V4_GEC Plans - Early Grading.pdf Markup Summary

Subject: Callout
Page Label: C4.10
Author: CDurham
Date: 5/19/2026 4:21:45 PM
Status:
Color: ■
Layer:
Space:

DP1 LOW POINT SWALE
 0.16% SLOPE, Q100=22.3cfs, FLOW DEPTH=1.18'
 VEL=2.51fps
 UPSTREAM INV=5803.80, DOWNSTREAM INV=5802.00
 LENGTH=1140'

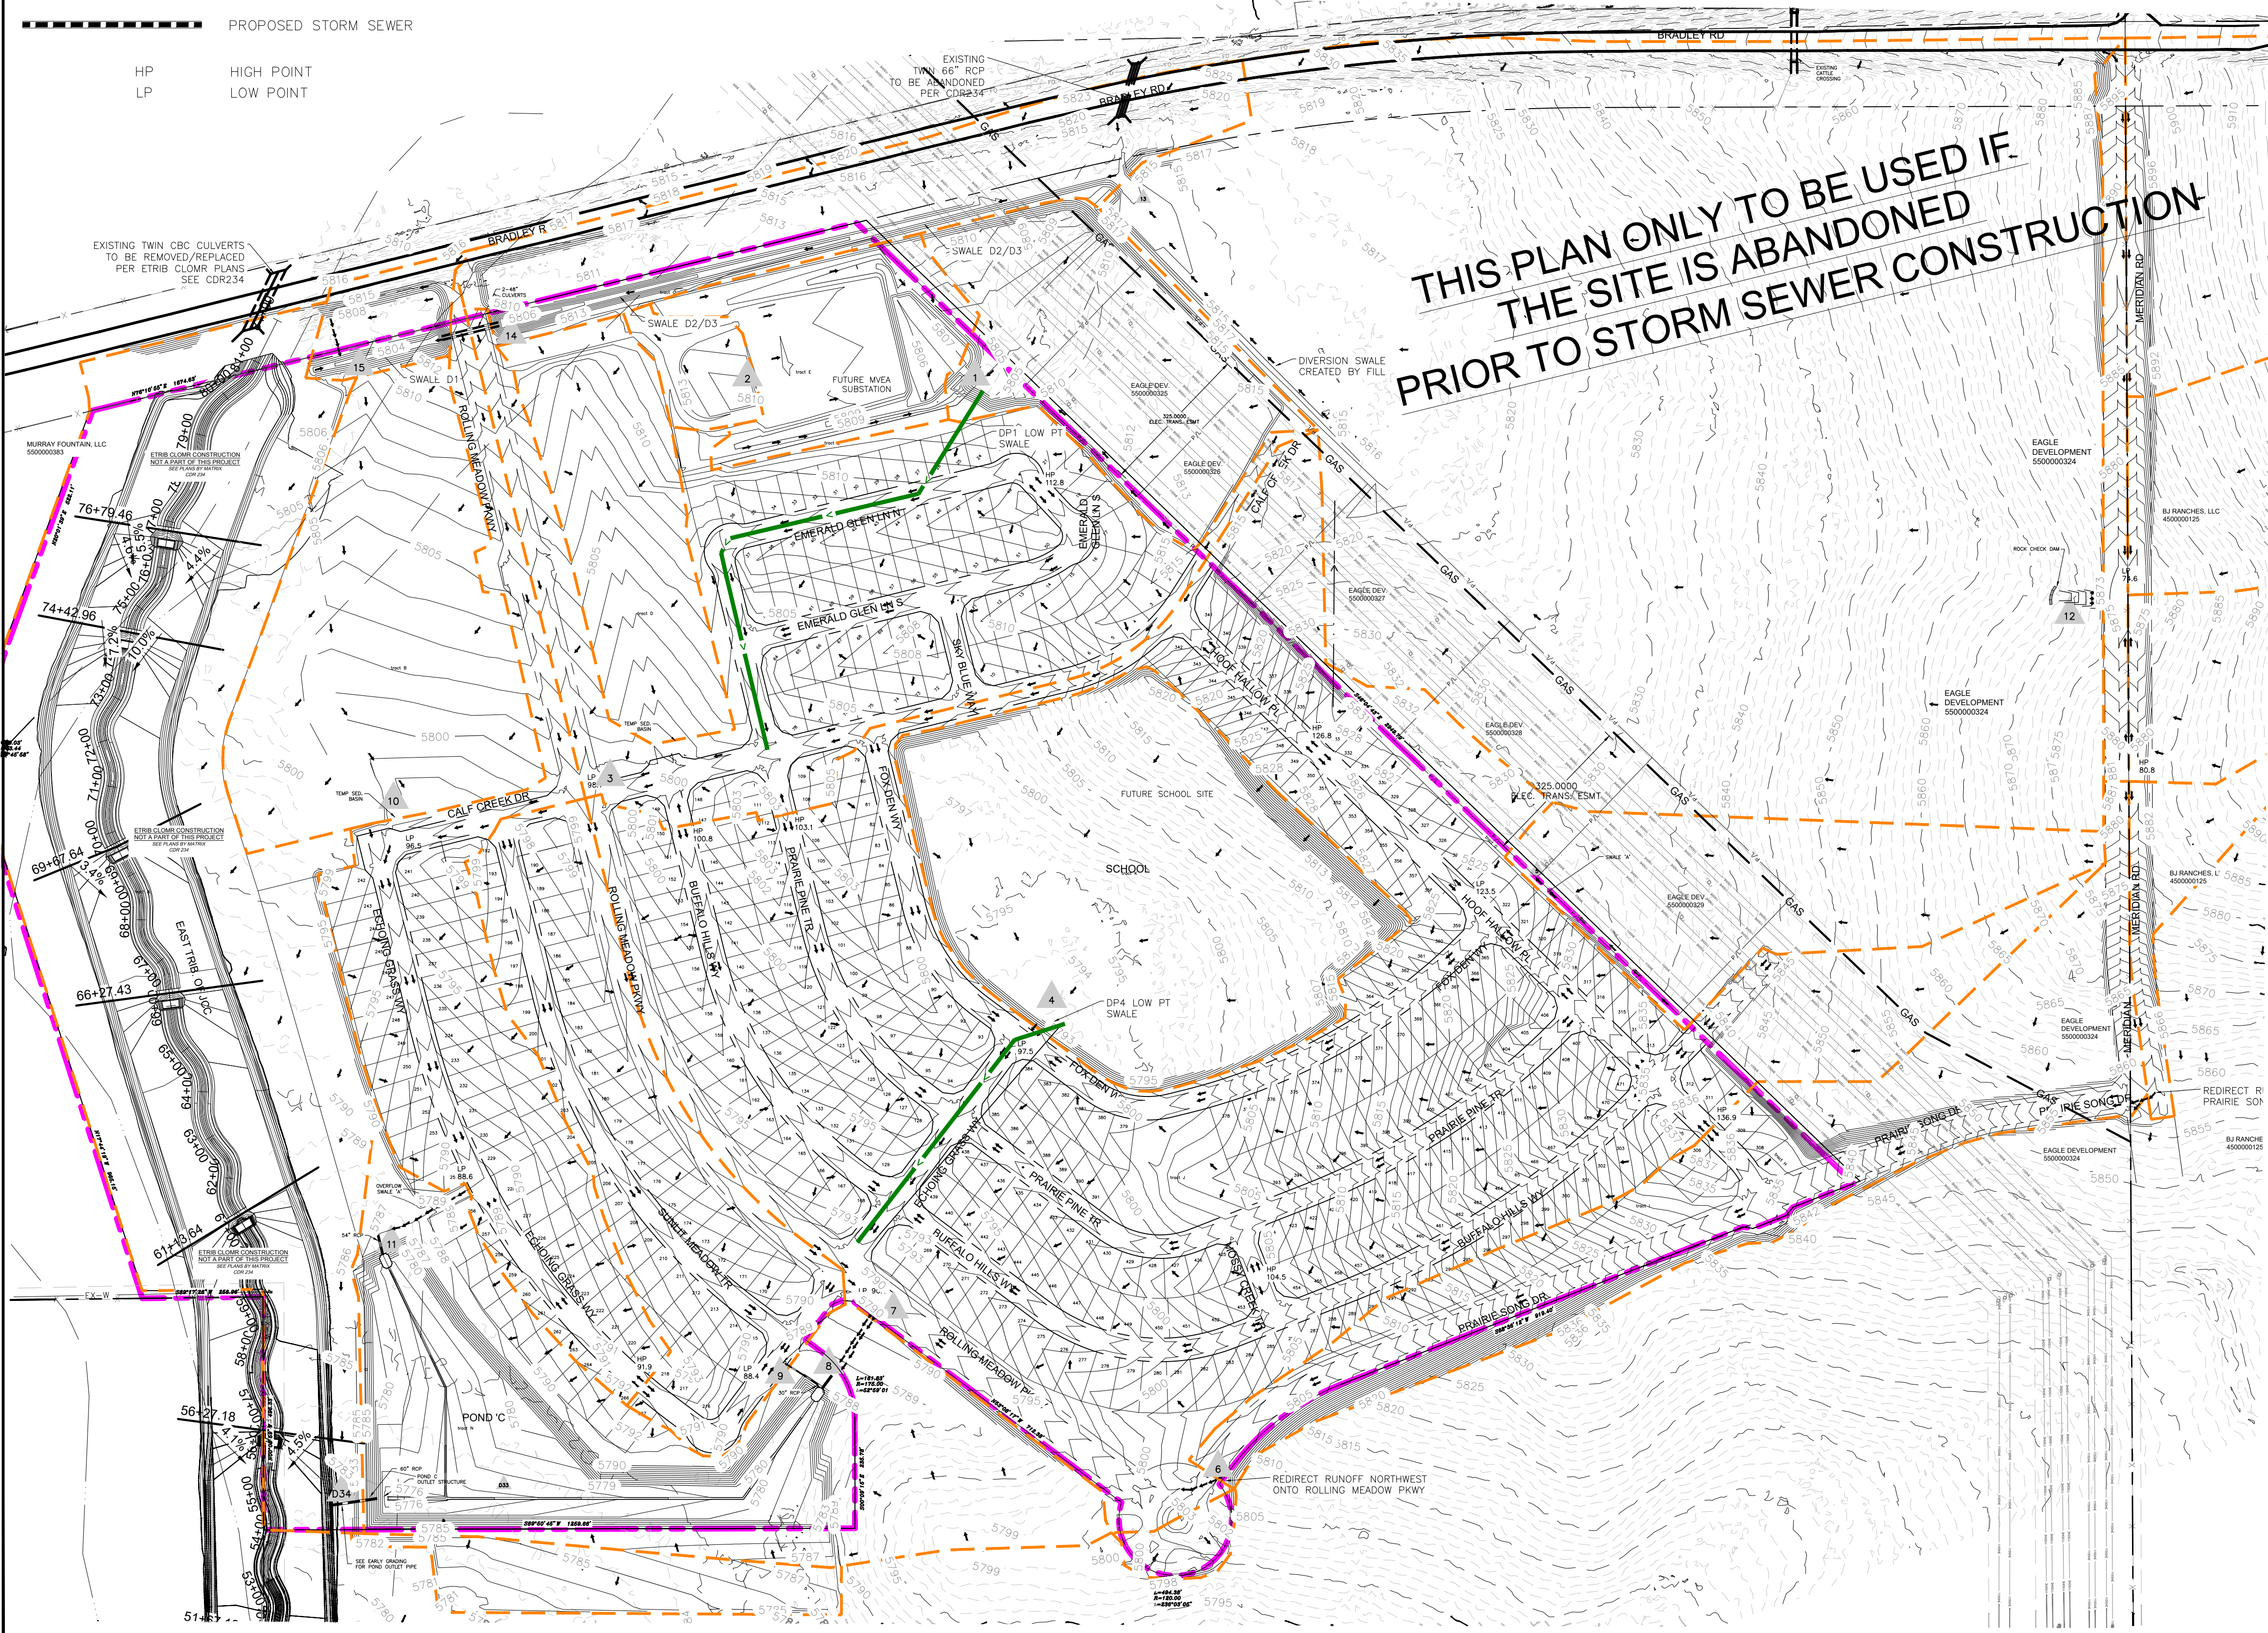
Provide detail for diversion berm or reference which swale detail from EC-10. Believe berm should be more than just dirt, as flows will erode at sides.

a specific detail for the berm is added to this sheet. ECB is also added to address erosion potential in the swale and reference to EC-10 as well.
